Recommendation Report for Planning Permission for Works or Extension to a Dwelling

REF NO: BR/198/21/HH

LOCATION: 88B Nyewood Lane
Bognor Regis
PO21 2TT

PROPOSAL: Single storey rear extension

sheet 1 of 3

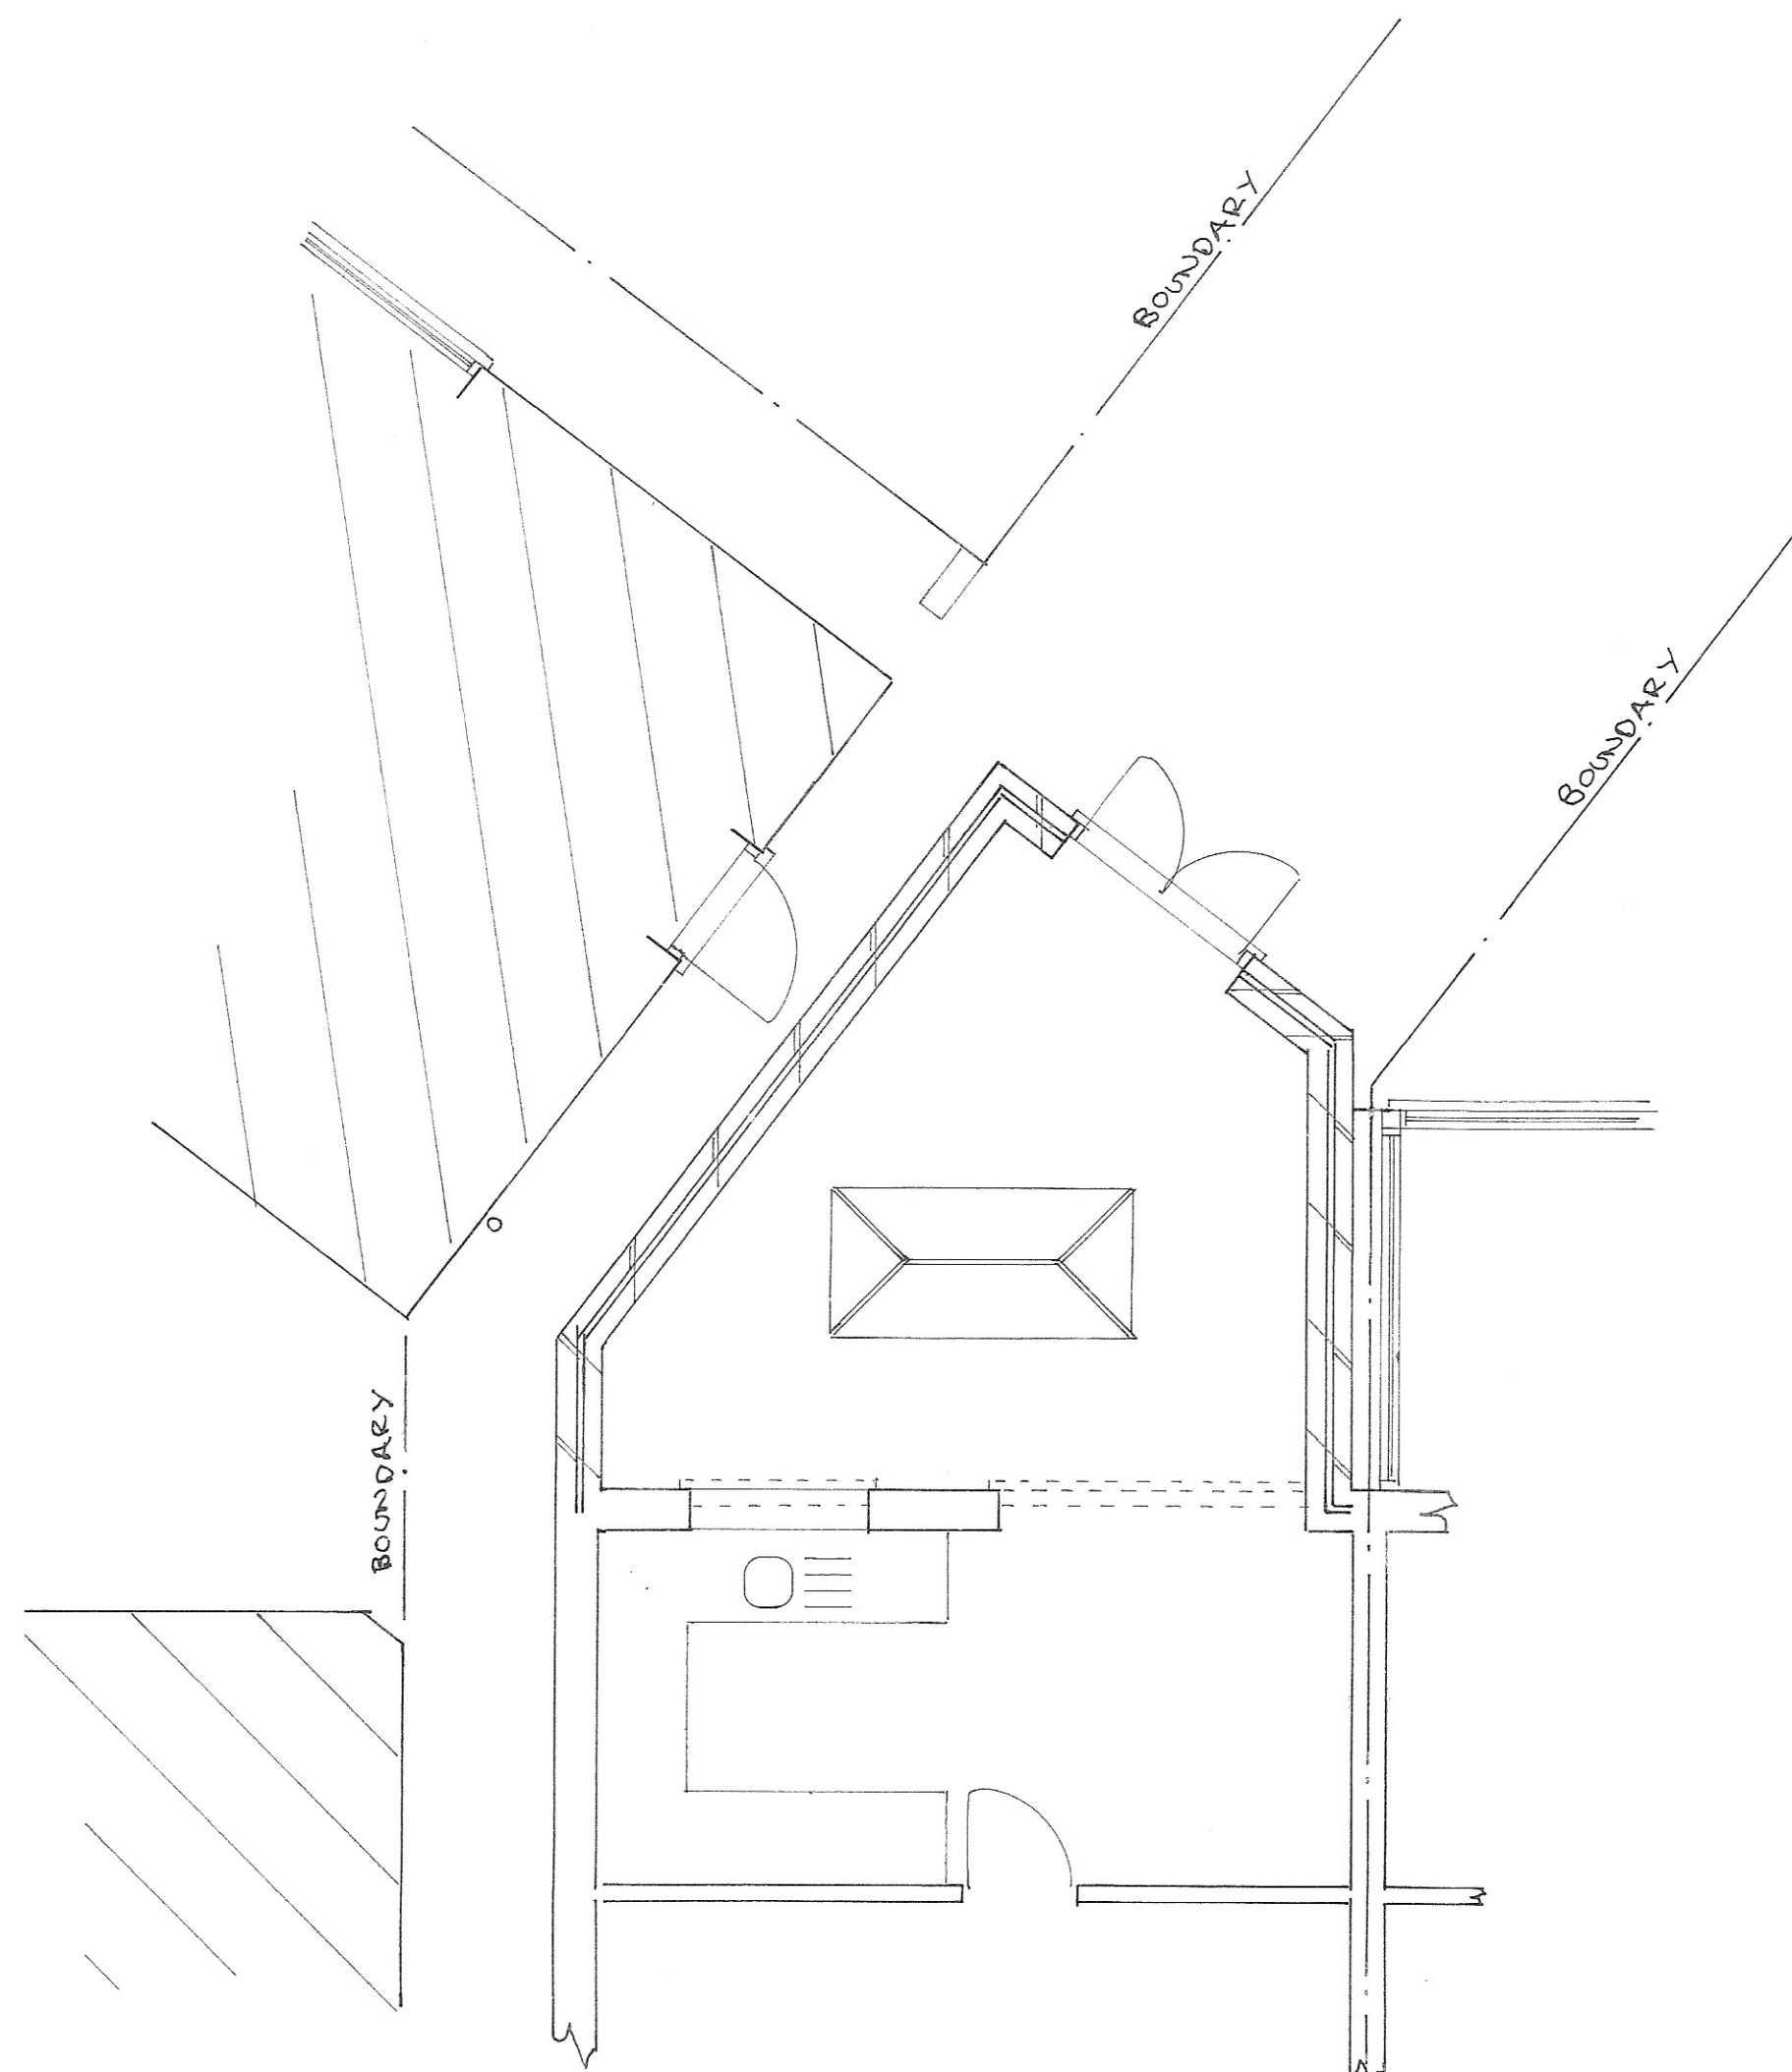
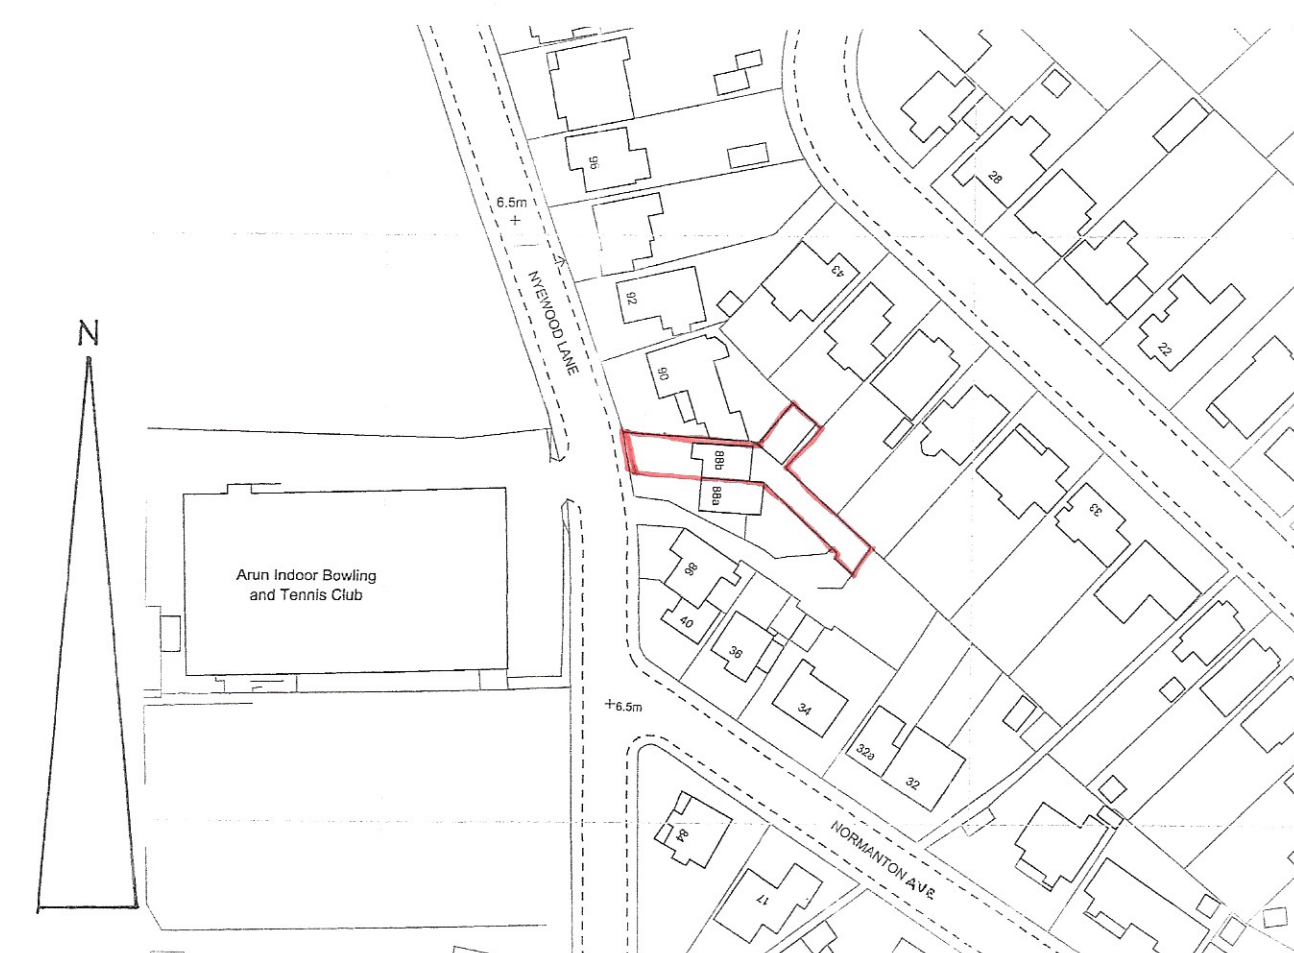
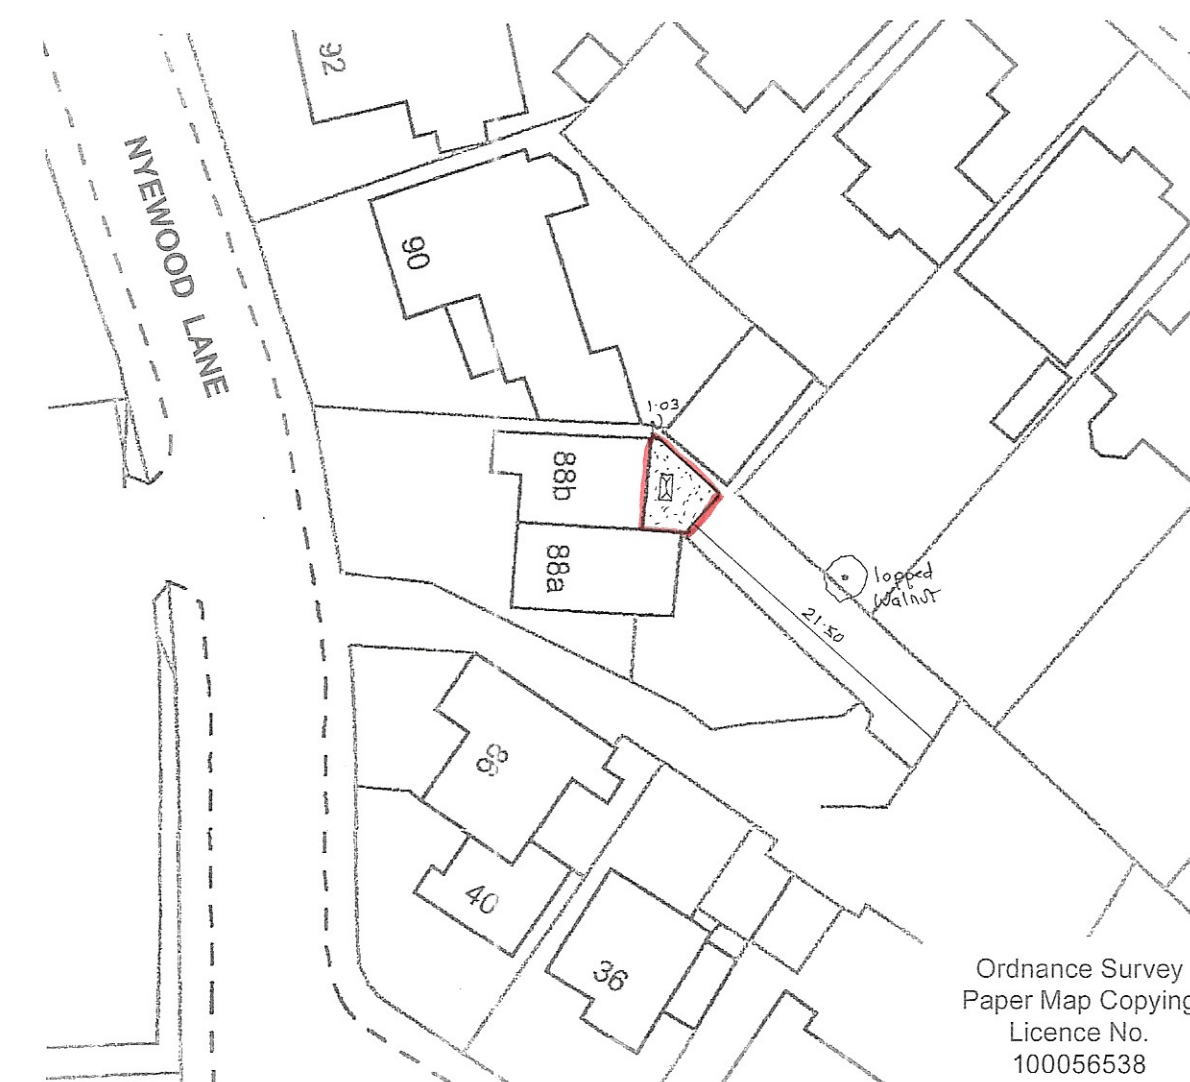
The proposal has a width of approximately 5.33m and a depth of approximately 5.50m from the rear principal elevation. The height to flat roof will be approximately 2.86m and to top of roof light will be approximately 3.35m. There will be 2 new French doors to rear (east) and 1 new roof lantern light.

The proposal has a width of approximately 5.33m and a depth of approximately 5.50m from the rear elevation. The height to flat roof will be approximately 2.86m and to top of roof light will be 3.35m. Due to a minimal gap remaining to the southern boundary there is increased risk to overshadowing or overbearing effects to neighbouring property number 88A to south. However due to being at single storey and existing boundary fence to south there is no refuseable adverse harm.

sheet 2 of 3

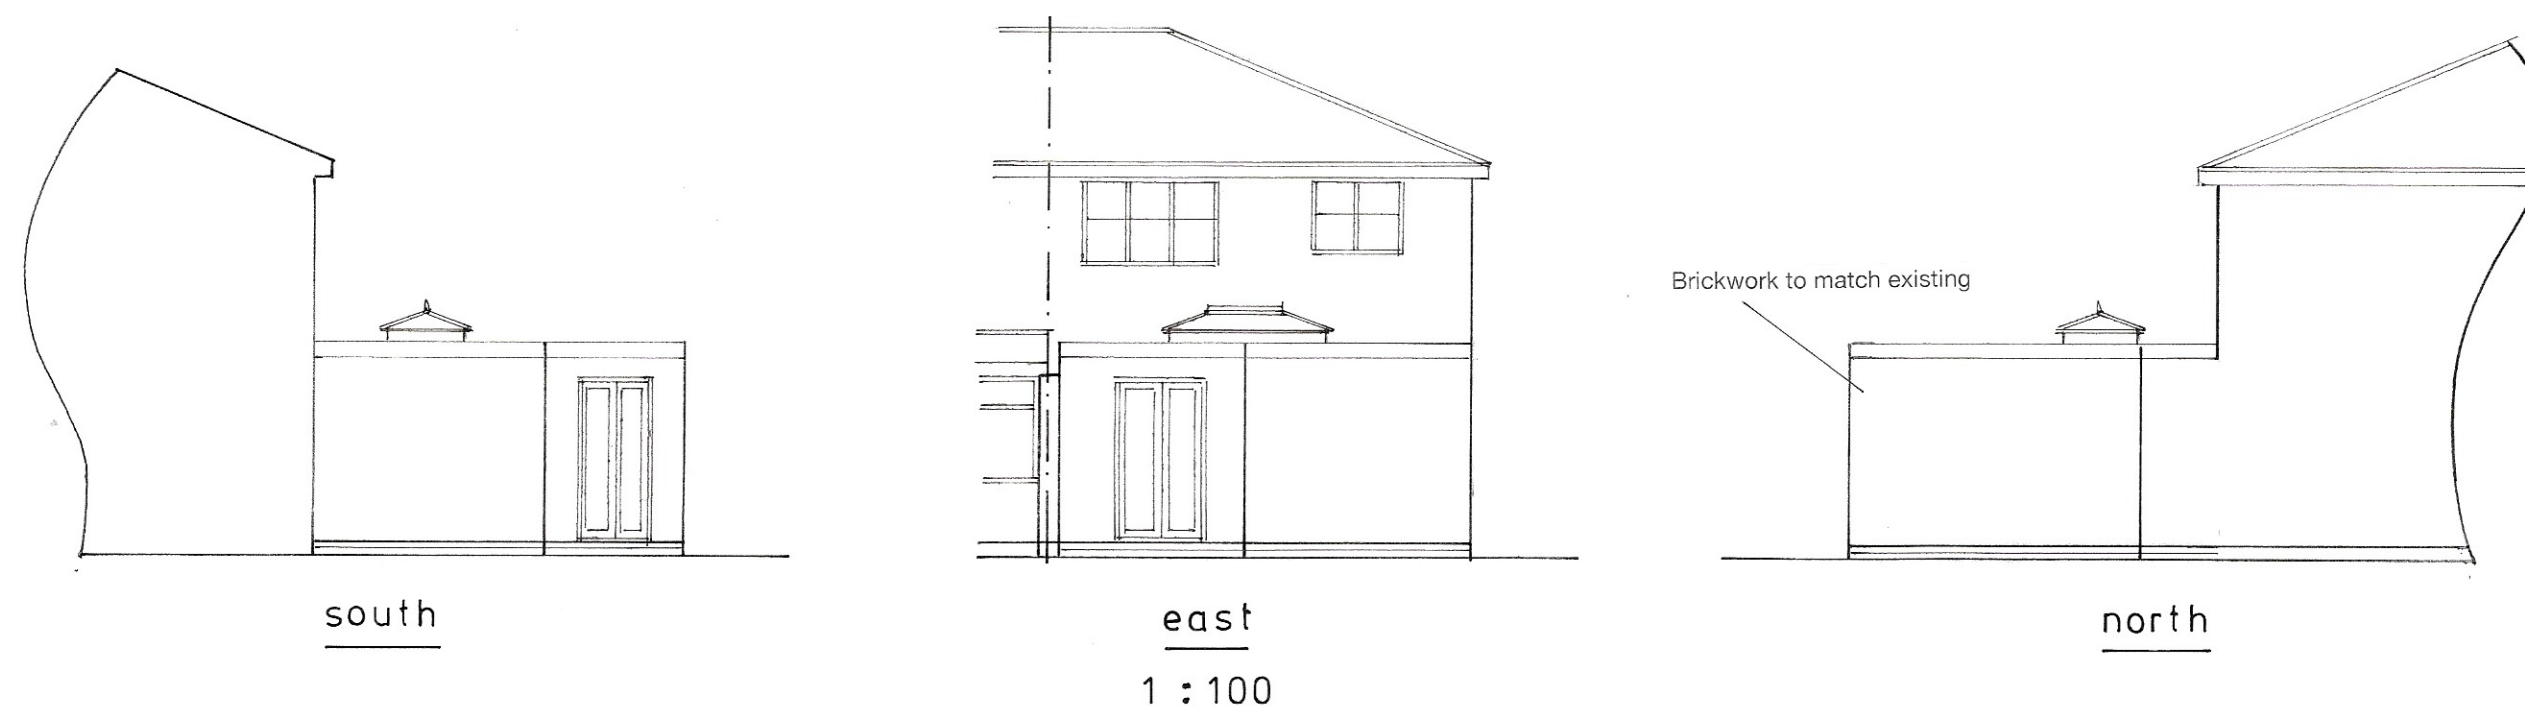
The materials seem to match existing property and consist of brickwork walls, felt flat roof materials, UPVC windows and doors so complies with policies D DM1 and D DM4 of the Arun Local Plan.

Due to new French doors to the rear (east) there is increased risk to overlooking to neighbouring property to south however due to siting of development and angle from proposal into garden of neighbouring property number 88A there is no adverse harm caused. Also the existing boundary fence to south will reduce impact of overlooking.
